Design, Access & Historical Impact Assessment

to accompany an application for listed building consent for

Can Court Cottage, Ampney St Peter, Gloucestershire, GL7 5SH December 2022

# WINDOW I & 2

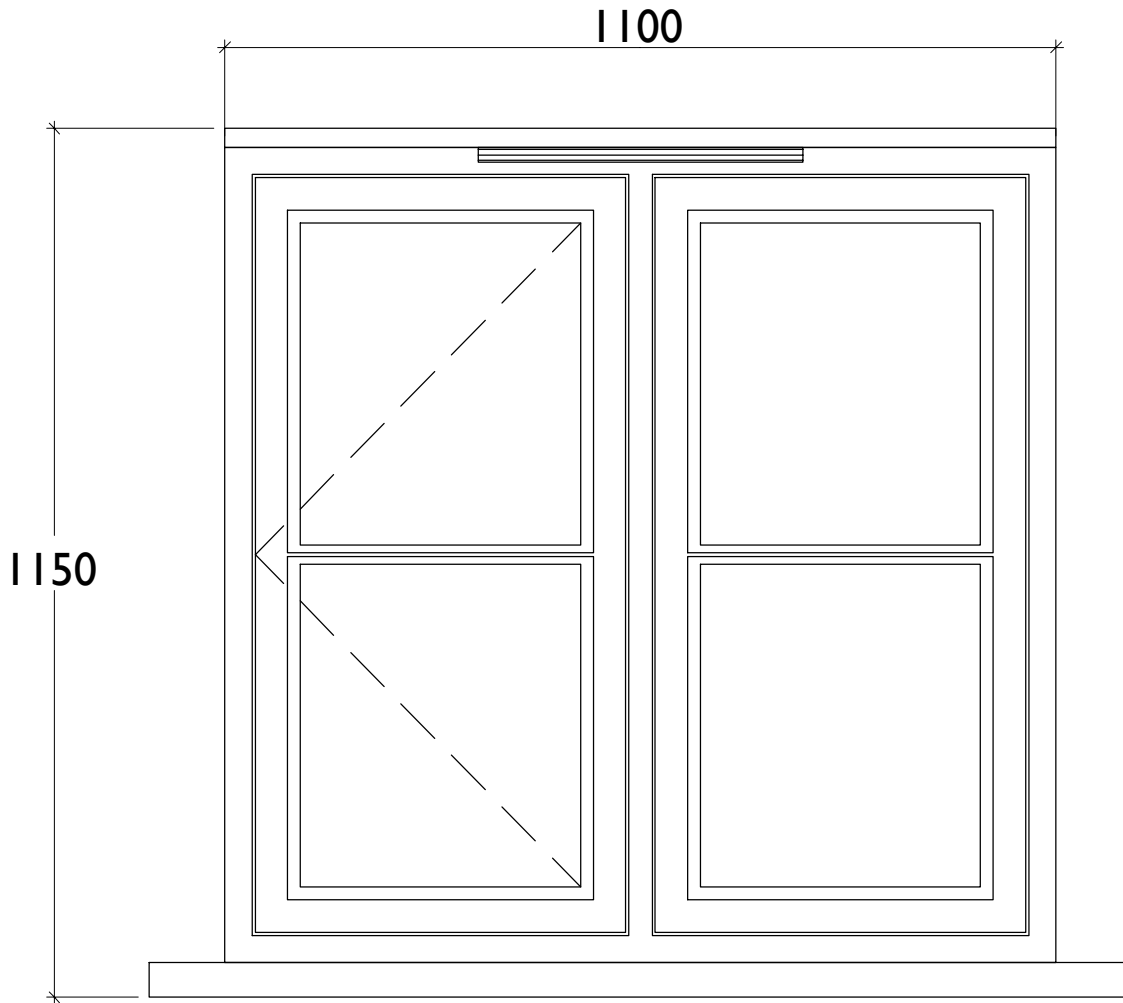
Consequently, there is no in principle objection to the replacement of Windows 2, 3 and 5, all of which appear to be modern. This notwithstanding, the information submitted in support of the application is unfortunately somewhat lacking in clarity and detail. In particular, whilst the submitted design and access statement makes reference to 'slim line' double glazing and 20mm glazing bars, the vertical and horizontal sections submitted in support the application depict 24mm double-glazing with no glazing bars. The insulated glazed units also appear to be internally beaded (as opposed to externally).

In order to sustain the character and significance of the listed building, the replacement windows (i.e. 2, 3 and 5) should be flush-closing timber casements with single horizontal glazing bars subdividing the insulated glass units (IGUs). The glazing bars should be traditional 'through' glazing bars (and not applied to the surface of the glass), and the IGUs should be slim profile (10mm to 16mm), and held in place externally with sprig and putty, or simple chamfered glazing beads. The frames should be solid hardwood, or a good quality slow grown softwood, and not engineered or composite. Whilst there is no in principle objection to the simplification of the existing glazing pattern in Window 5 (large oriel window in the north gable-end of the building), as multi-pane double-glazing, even where slim profile, can appear 'chunky', and as a result of the incorporation of multiple units more susceptible to thermal bridging, details of the glazing pattern for each window in the form of scale drawings (elevations) and sections (full horizontal and vertical) have not been provided.

Whilst there is no objection in principle to the replacement of Windows 2, 3 and 5 with new double-glazed timber windows, conflicting information has been provided in support of the application with regard to the thickness of the proposed double-glazing, the glazing bars, and the glazing patterns. As such, insufficient information has been submitted in support of the application to enable the Local Planning Authority to understand the potential impact of the proposals on the special interest and significance of the listed building. In particular, 24 mm double-glazing is highly unlikely to be considered acceptable, given the thickness of the individual units, the increased thickness of the glazing bars required to support the weight double-glazed units, and the incorporation of spacer bars and edge seals.

West (Roadside) Elevation

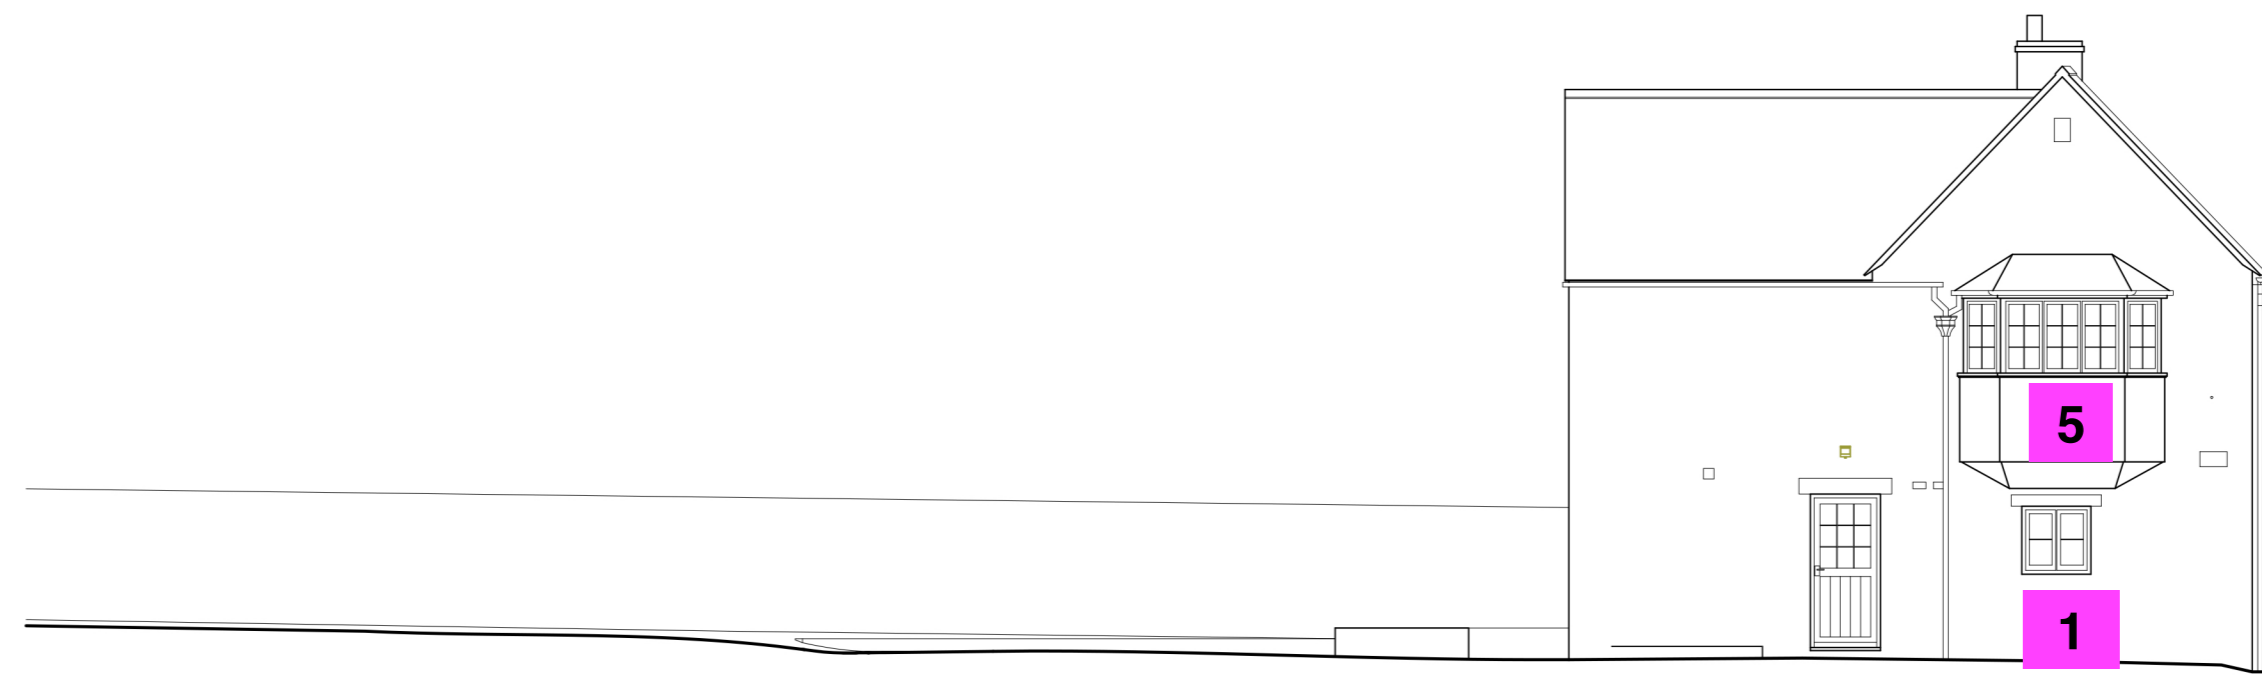
In the absence of a full condition survey report, or a clear and convincing justification for their replacement, it is therefore the opinion of Officers that Windows 1, 4 and 6 should be retained and repaired on a like-for-like basis. If seeking to improve the thermal performance of these windows, secondary glazing should be considered.

The replacement of Windows 1, 4 and 6 with new double-glazed timber windows would result in the loss of surviving historic features that by virtue of their design, materials, construction, glazing patterns, and method of glazing, make an important contribution to the special interest and significance of the listed building. Furthermore, no clear or convincing justification has been provided in support of the application as to why these windows cannot be repaired.

In light of the above, please advise if you wish to proceed to determination (Officer recommendation for refusal), withdraw the current application, or submit amended details addressing the above concerns. If the latter, please note that this should include confirmation that windows 1, 4 and 6 are to be retained and repaired on a like-for-like basis, and scale drawings showing the glazing patterns for replacement Windows 2, 3 and 5, together with full horizontal and vertical sections showing the glazing bar profiles and thickness of the double glazed units. Please note that if not held in place with putty, the glazing should be beaded externally, not internally."
